Recommendation Report for Planning Permission for Works or Extension to a Dwelling

REF NO: FG/24/25/HH

LOCATION: 148 Littlehampton Road
Ferring
BN12 6PH

PROPOSAL: Detached garage to front garden. Infill extension linking main house to existing garage and part conversion of existing garage to home office.

Drawing No. 25/148/1

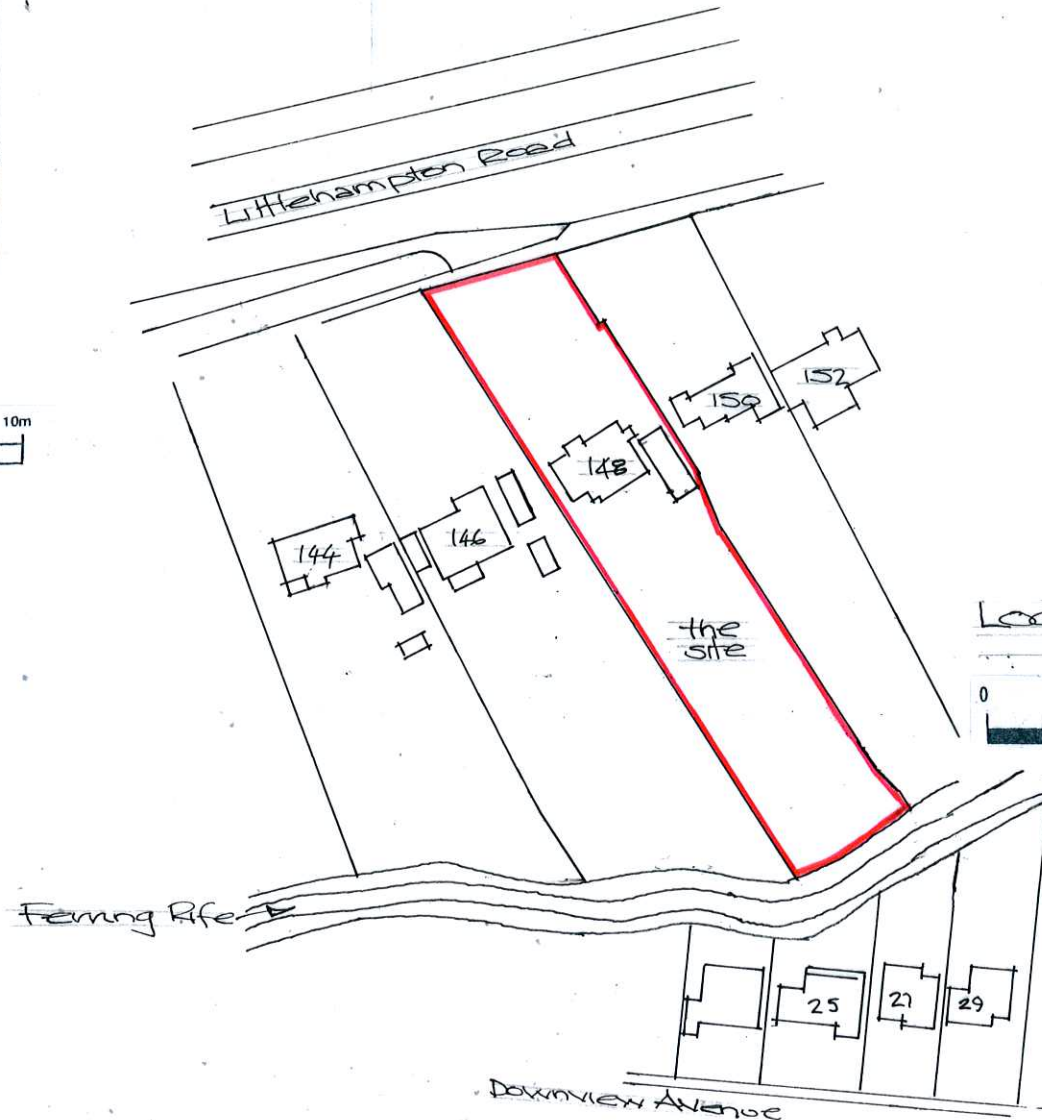
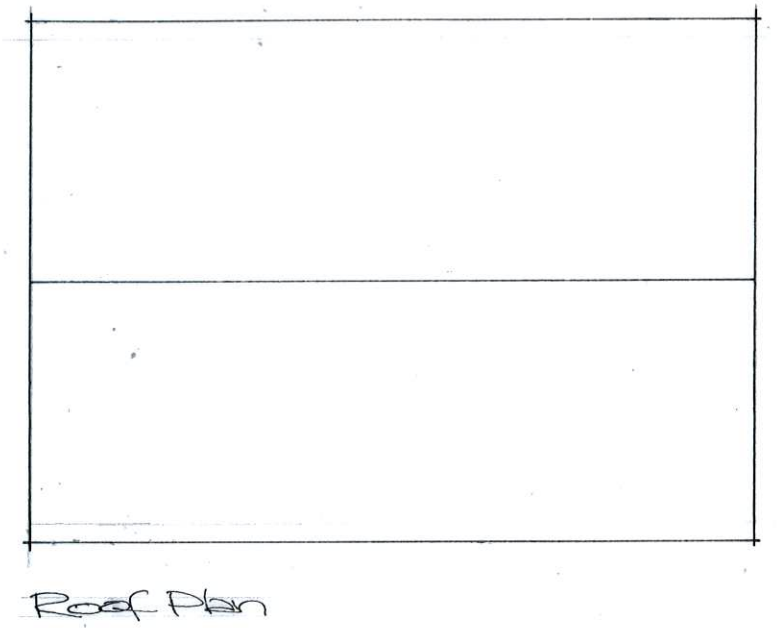
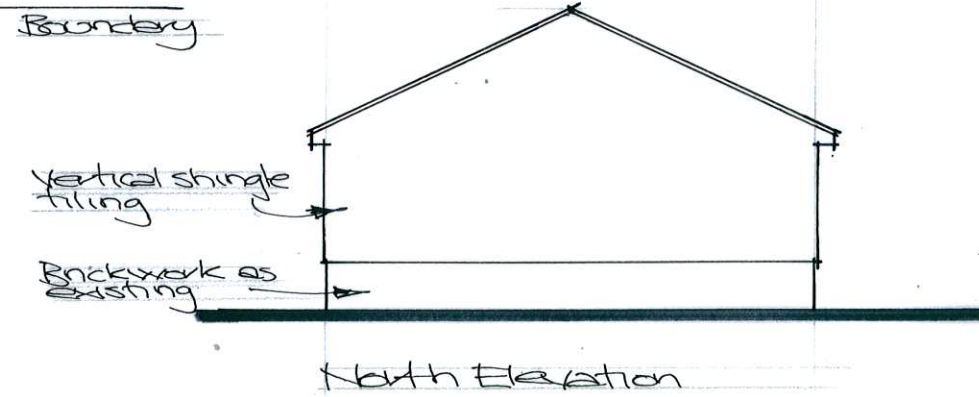
The site comprises a detached dwelling along Littlehampton Road. The proposed detached garage would be sited to the north-west corner of the plot and would extend forward of the existing front elevation line. The garage will disrupt the dominant building line along this part of Littlehampton Road, however the siting of the garage would be acceptable in this instance as it would be set back from the highway by approximately 16.5m. This distance minimises the impact of the detached garage on the street scene. The garage would be approx. 9.3m deep and approx. 6.3 wide. It would have a pitched roof with a ridge height of 4.1m and an eaves height of 2.5m. The proposed materials include facing brickwork and shingle tiles, which would match the materials of the host dwelling. Whilst large in scale, the proposed garage would be set back from the front boundary of the site, and it is noted that a neighbouring dwelling has constructed an outbuilding to the front of the site of a similar scale. As such, the proposed garage would not appear unduly prominent within the street scene, nor would it result in demonstrable harm to the character or appearance of the host dwelling.

The proposed garage would be set in 0.7m from the north-eastern side boundary. The garage would extend forward of the established building line. However, given that the eaves height of the garage would be low level, measuring 2.5m, the garage would not result in any overbearing or overshadowing effects. The proposed garage would include a garage door inserted within the side (west) elevation and would not result in any overlooking.

Drawing No. 25/148/3

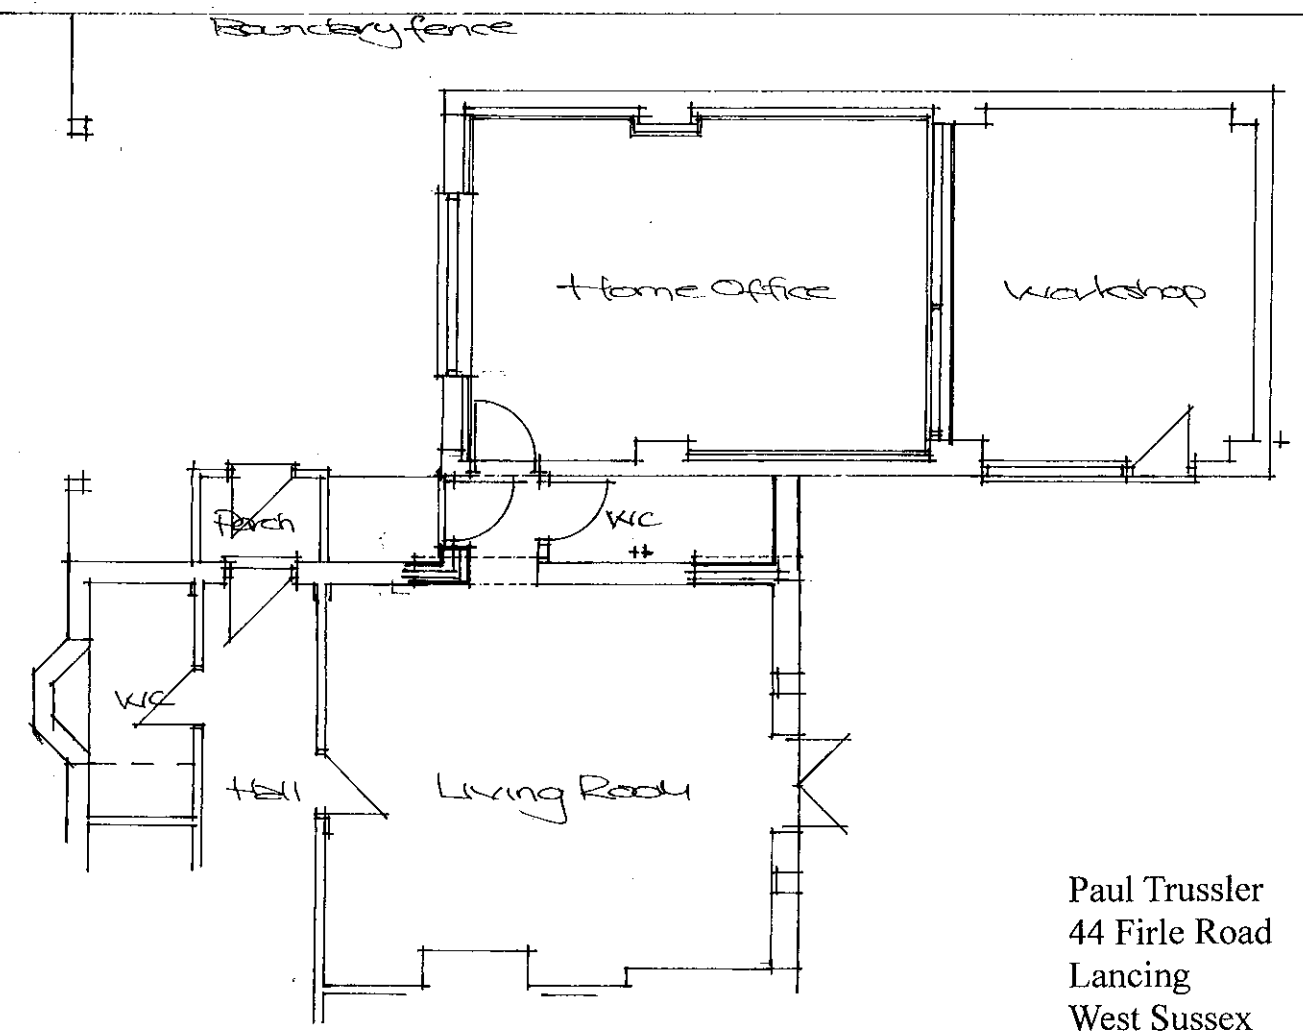
The proposed extension would infill the space between the side (east) elevation of the host dwelling and the detached office space to the side (east), with a maximum width of 1.5m from the eastern flank elevation of the host dwelling, and a depth of 5m. The extension would have a flat roof form with a maximum height of 2.8m. Fenestration is proposed within the north (front) elevation of the extension. The proposed materials include facing brickwork and flat roof with felt roofing, the materials proposed for the walls would match the materials of the host dwelling. The proposed side extension would be small in scale and as it would be an infill extension, it would not significantly alter the built form. The proposed side extension is acceptable.

The proposed infill extension is a minor extension and the extension would not result in any overbearing, overshadowing or overlooking effects or loss of privacy. The door proposed along the front elevation would have an outlook of the front amenity space and would not appear overbearing in its context.
